From: [Ellie Worth](#)
To: [DCAdmin](#)
Subject: FW: Planning Application 2023/91212 - Erection of 16 dwellings off Laithe Avenue
Date: 26 May 2023 07:40:26
Attachments: [PXL_20230514_083945496.jpg](#)

Sent: Thursday, May 25, 2023 8:07 PM
To: Ellie Worth <Ellie.Worth@kirklees.gov.uk>
Subject: Planning Application 2023/91212 - Erection of 16 dwellings off Laithe Avenue

Bankfield Drive, Holmbridge

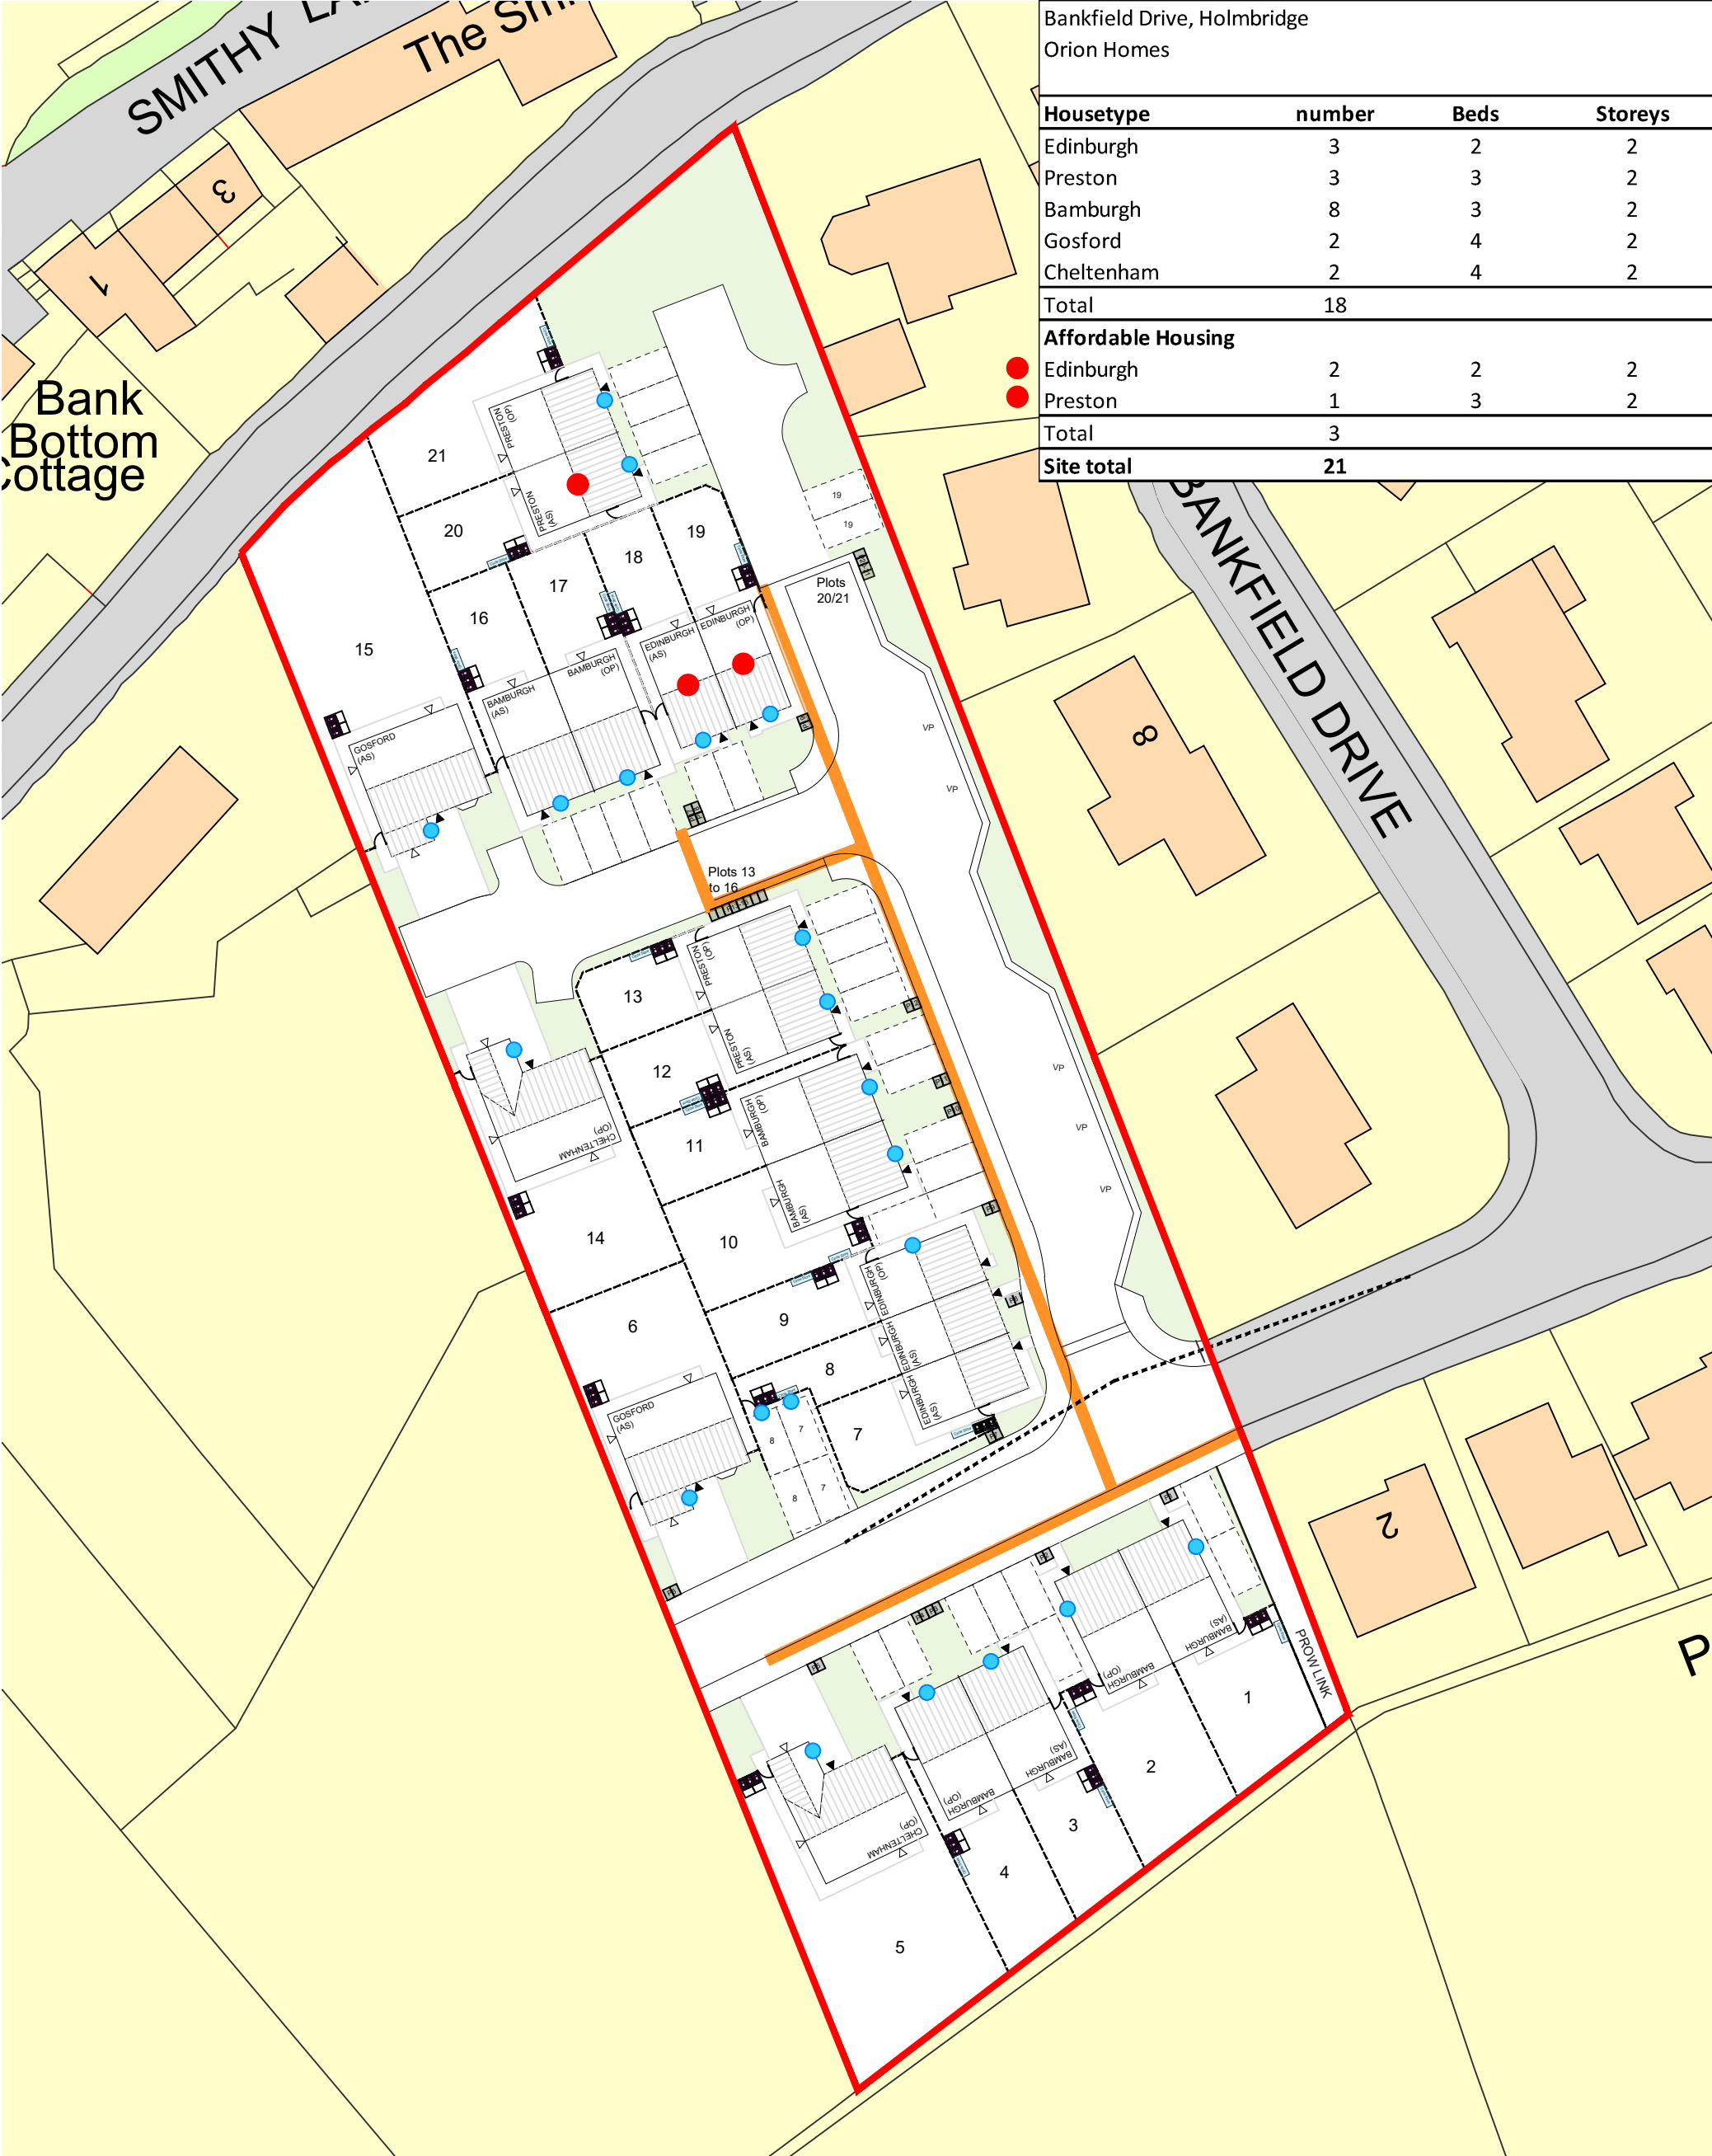
As the plans stand at present, there is a distance of 4.5 metres from our glass front door, hall window and living room window to the plot number one and a distance of 7.5 metres to the house wall of plot one, which is far short of the 12 metres recommended.

I would also like to point out that in the planning application, the design of plot 1 (Falmouth AS) does not correspond with the house design on the general plan which shows plot 1 as Falmouth OP? It would be appreciated if the plans could be updated to show the correct design of plot 1 as it is difficult to work with inaccurate data and make comments on conflicting designs.

As also mentioned in our phone conversation the other day, the PROW has been marked as next to our house, please can you confirm if the applicant has obtained permission for a right of way

on to the footpath over the field boundary wall as if not, the PROW is not feasible and should not be included on the plans.
